Ref: EN010163 - Response from NCC

Steeple Renewables Project

With regard to the recent request for comments relating to additional information dated the 25th August 2026, NCC have the following comments to make.

DRAWING NUMBER

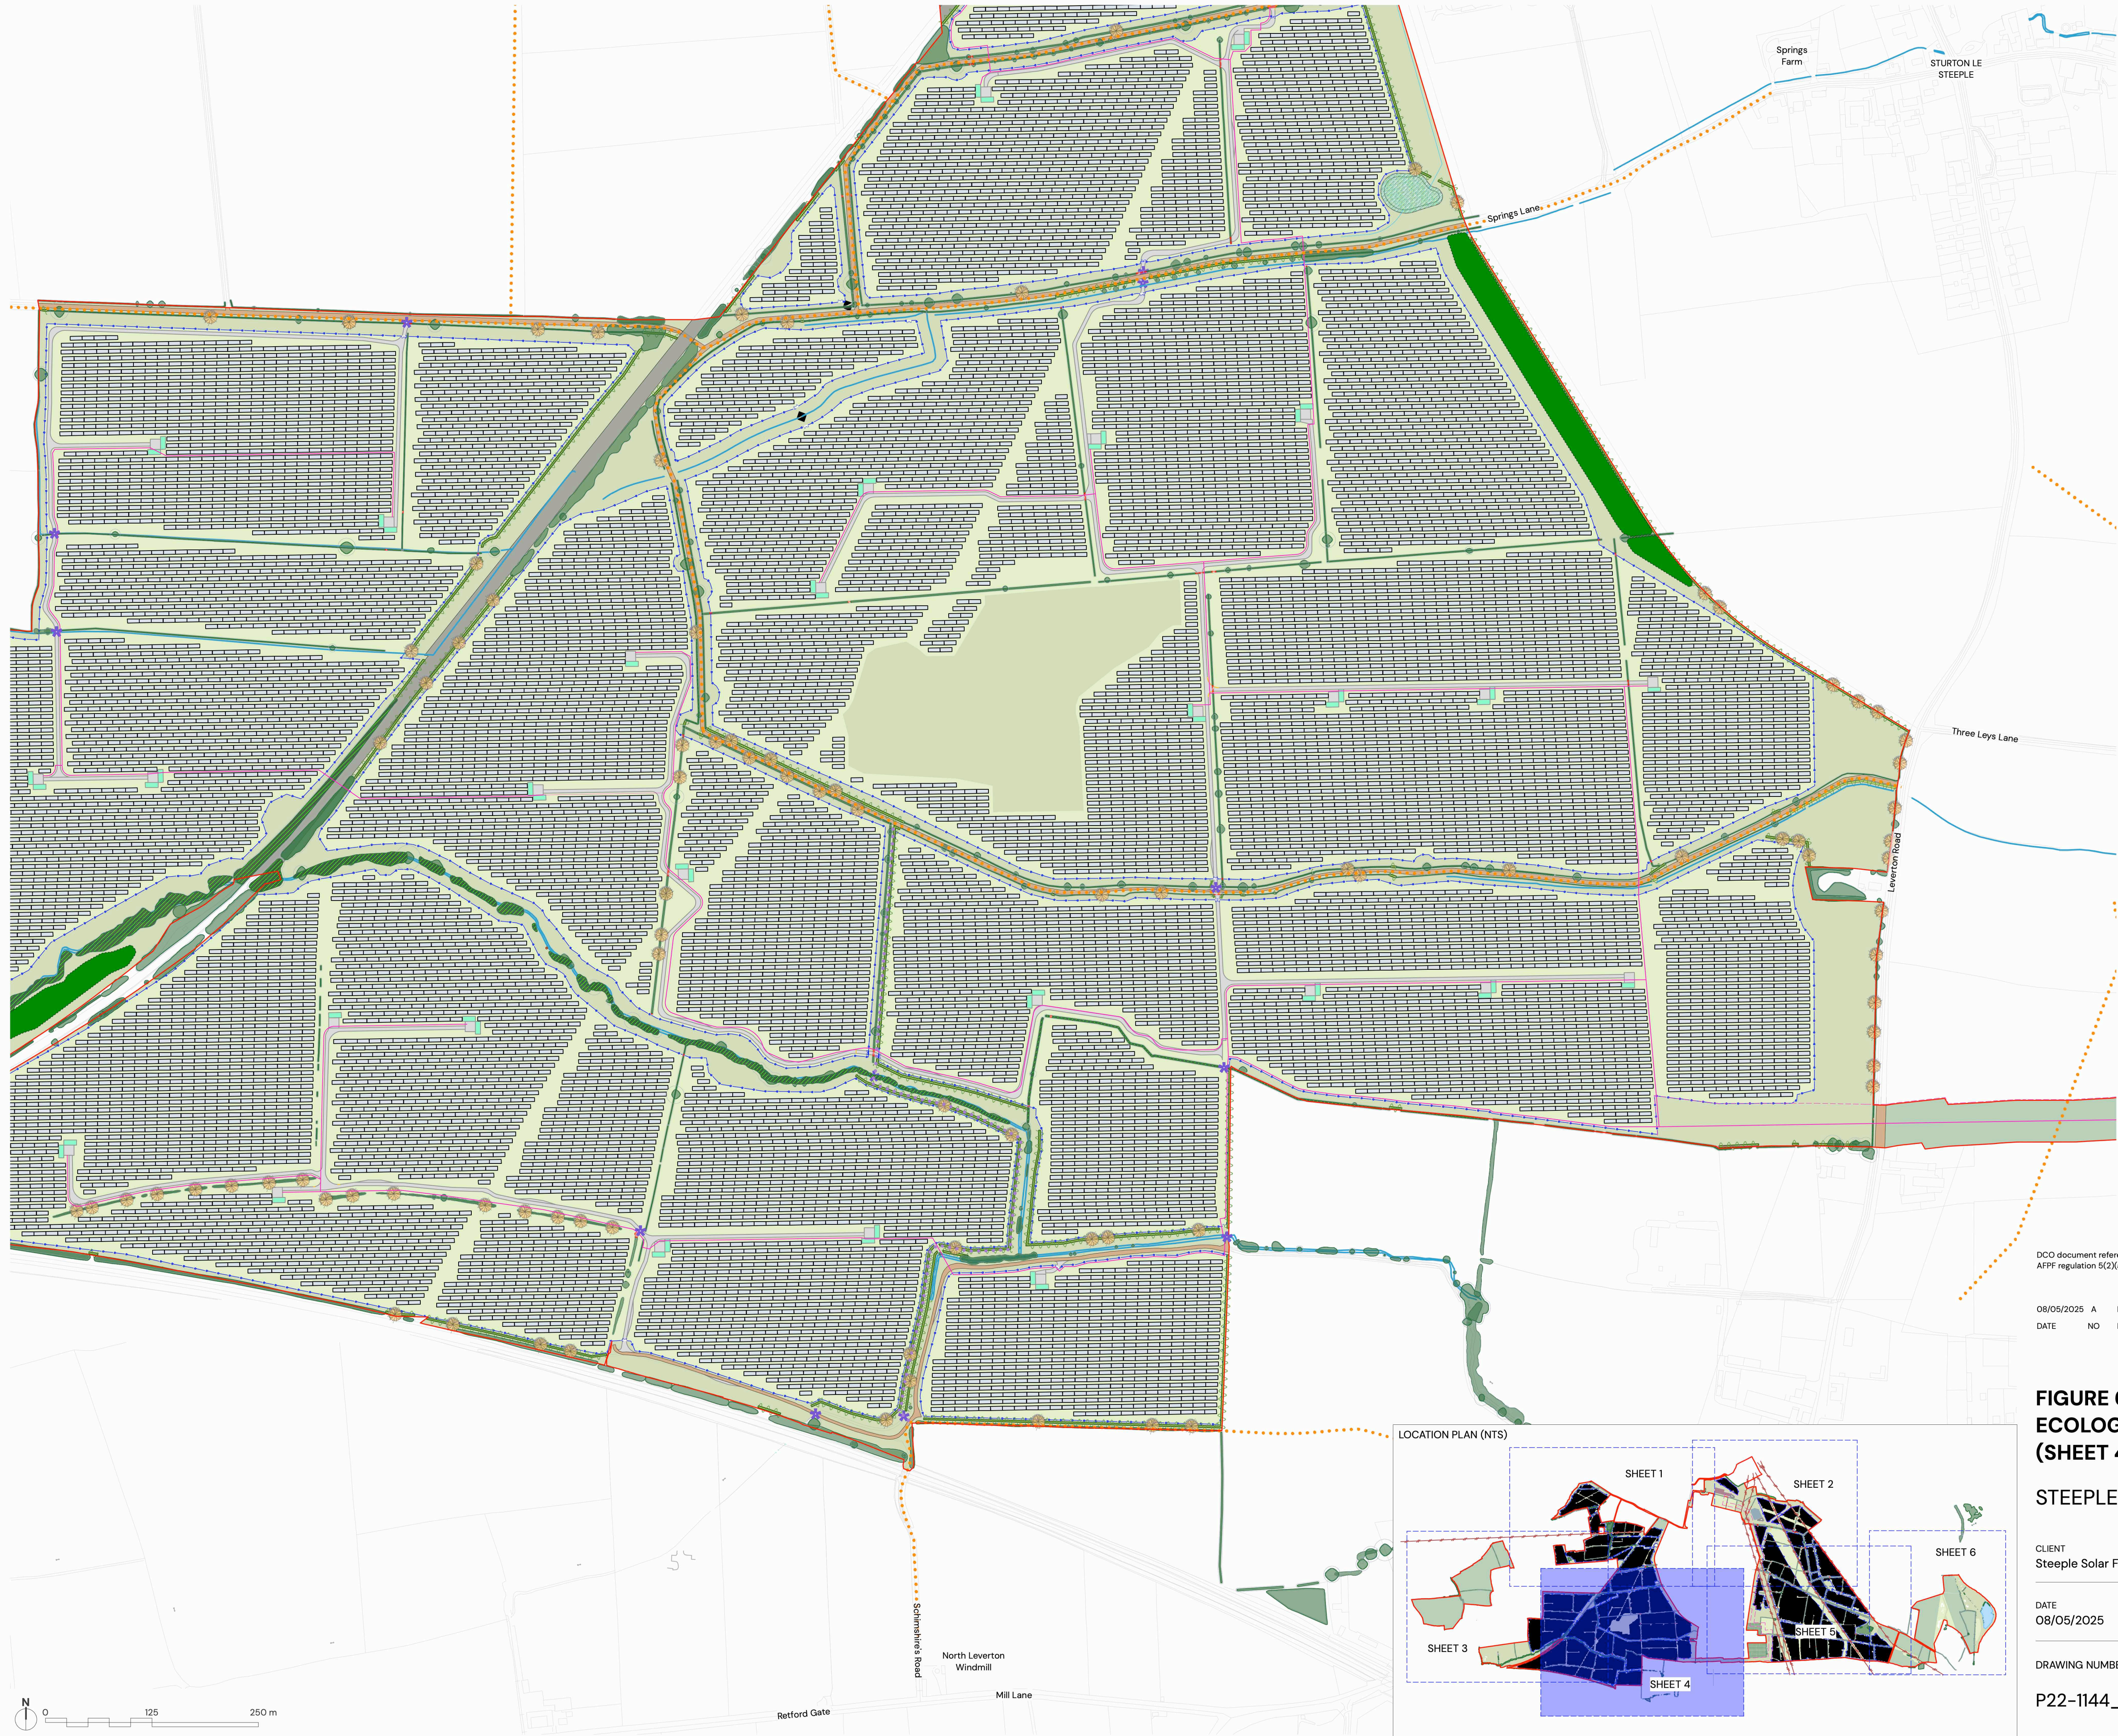
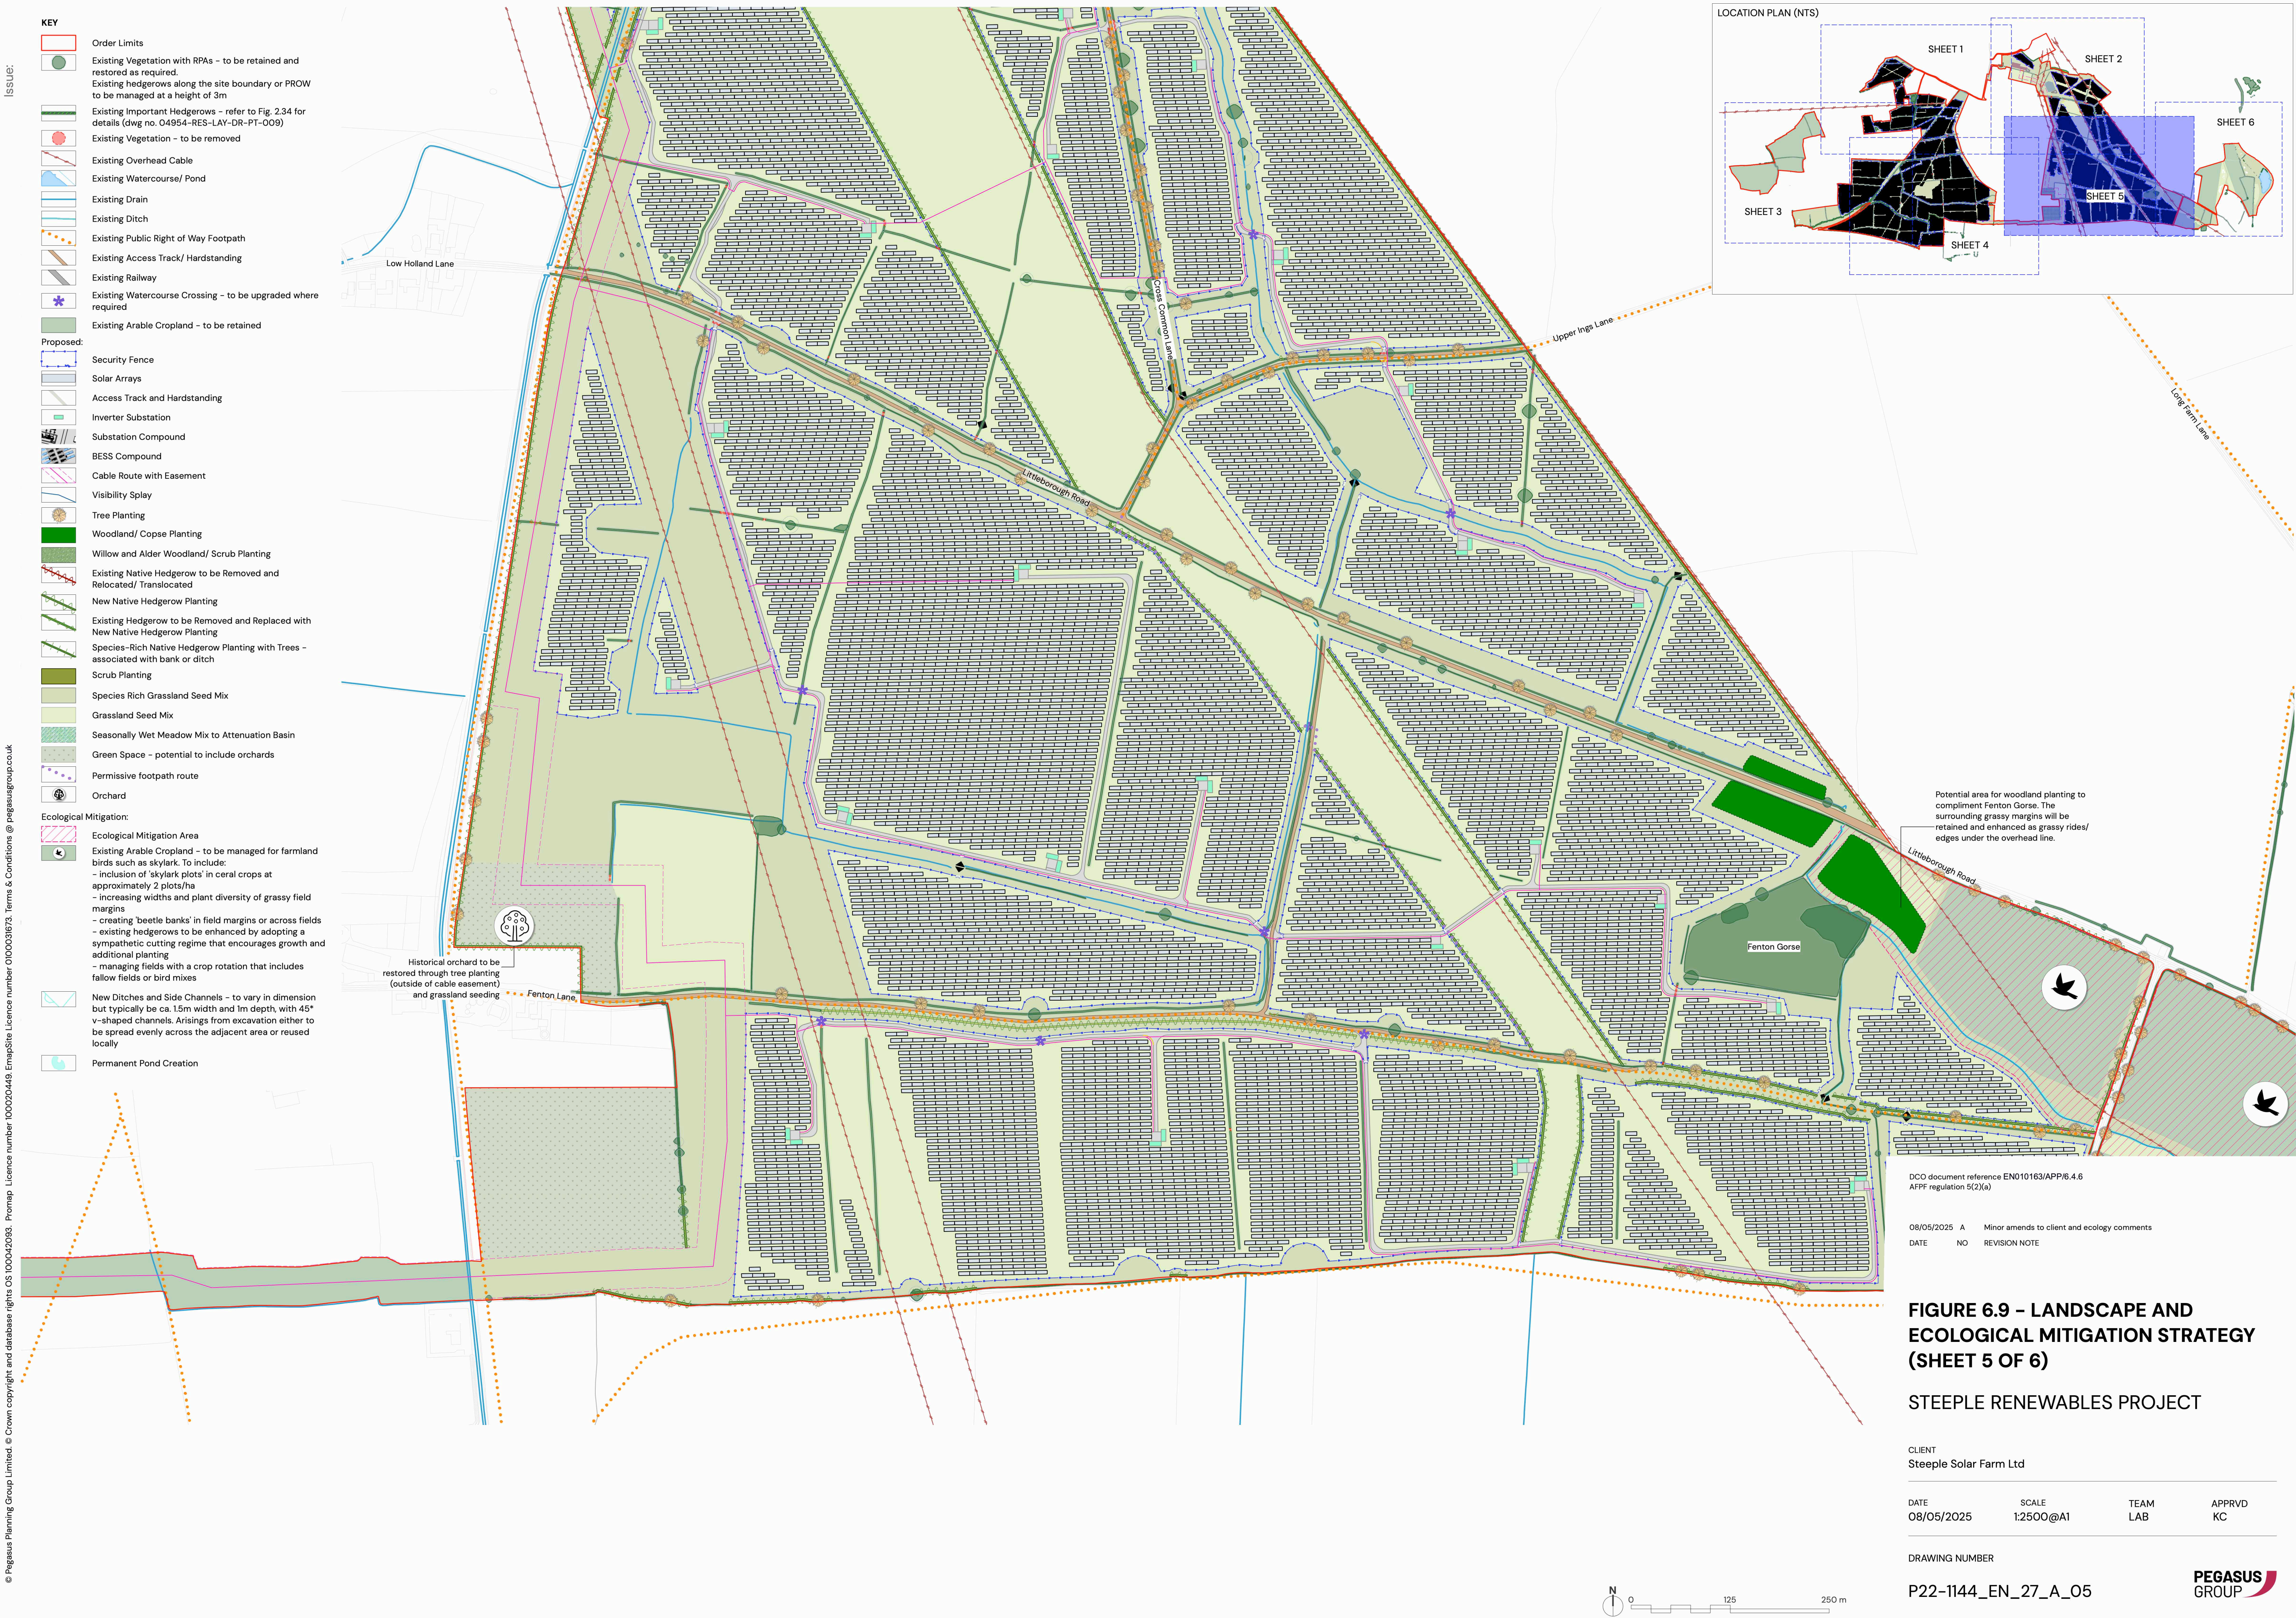
The additional native hedgerow proposed to the western side of the BESS is welcomed and is considered to provide an appropriate additional layer of landscape mitigation. Its location close to the BESS compound should assist in filtering and softening views of the perimeter infrastructure in combination with existing and previously proposed vegetation.

It is agreed that the additional planting is unlikely to result in a change to the significance conclusions reported within the ES. However, it would be more accurate to recognise that the planting is expected to provide a slight further reduction in the degree of visual effect as it establishes, notwithstanding that this would ultimately not alter the reported significance judgement.

The final LEMP should clearly identify the additional hedgerow and provide an appropriate planting specification including species composition, planting density, establishment and management proposals and intended management height and width. I note that existing and enhanced hedgerows are proposed to be maintained at approximately 2.5m in height and 1.5m in width. It should be confirmed whether these dimensions would also apply to newly created hedgerows once established.

The final arrangement should allow sufficient separation between the proposed hedgerow, Security fencing and BESS infrastructure to allow the planting to establish and be maintained effectively. NFCC guidance states that combustible vegetation should be at least 3m from BESS infrastructure; however, engagement with the local fire safety officer should be consulted to confirm that the proposed arrangement and offsets are acceptable from a fire safety perspective.

From a landscape perspective, sufficient space should also be provided for long term maintenance access, with a minimum 2m maintenance strip recommended. The mature extent of the hedgerow should also be maintained at least 3m from the security fencing to reduce the potential for established vegetation to provide a climbing aid and compromise site security. The Applicant could also consider incorporating suitable thorny native species within the final hedgerow mix to provide an additional degree of natural deterrence.
